**Re: Status of Permit Application-SFD2510-0028, SFD2510-0029, SFD2510-0030 and SFD2510-0031**

An attempt was made to evaluate your property for issuing an Improvement Permit. The evaluation could not be completed for one or more of the following reasons.

PROPOSED PLAN FOR
GMC CONSTRUCTION OF NC, INC.
6645 RIVER ROAD, FUQUAY-VARINA, NC 27526
LOT 10 SONORA & JIMMY PRINCE
DEED BOOK 4300 PAGE 2932
MAP # 2025 - 525
PIN # 0625-66-2021.000
BUCKHORN TOWNSHIP
HARNETT COUNTY - NORTH CAROLINA
SCALE : 1" = 60' - OCTOBER 1, 2025

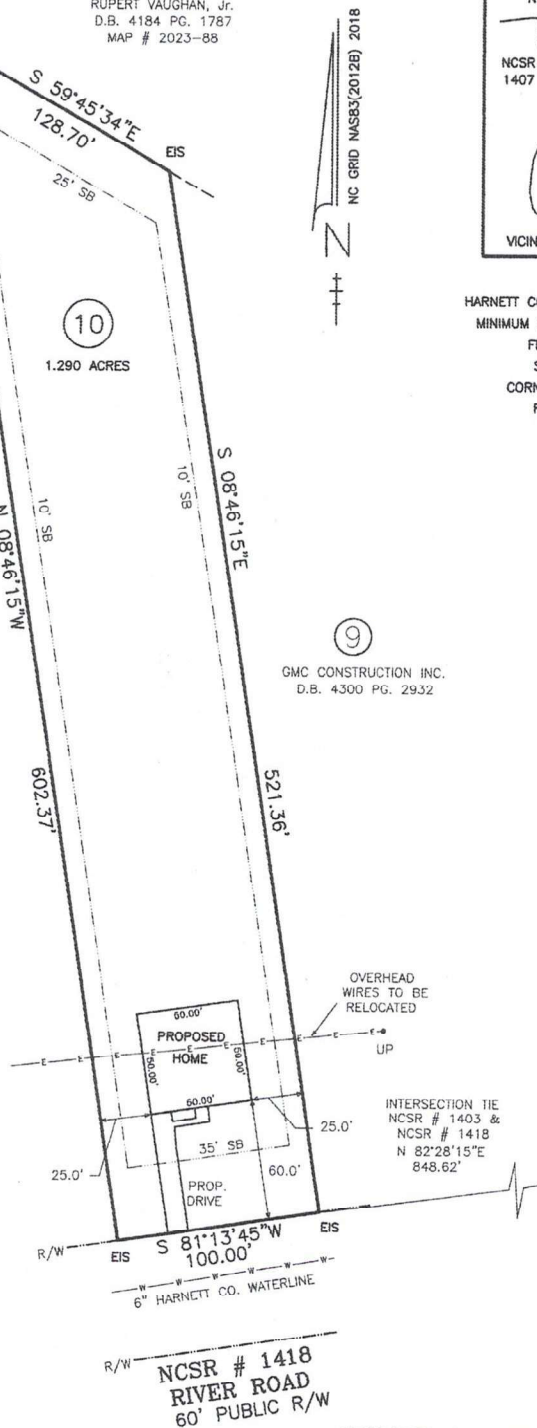
**X 1. Survey Corner Irons need to be uncovered and clearly demonstrated. Have surveyor flag/mark every 50' between property survey corner irons. (25.00 Fee Incurred)**

**X 2. House Box needs to be marked/demonstrated clearly. (25.00 Fee Incurred)**
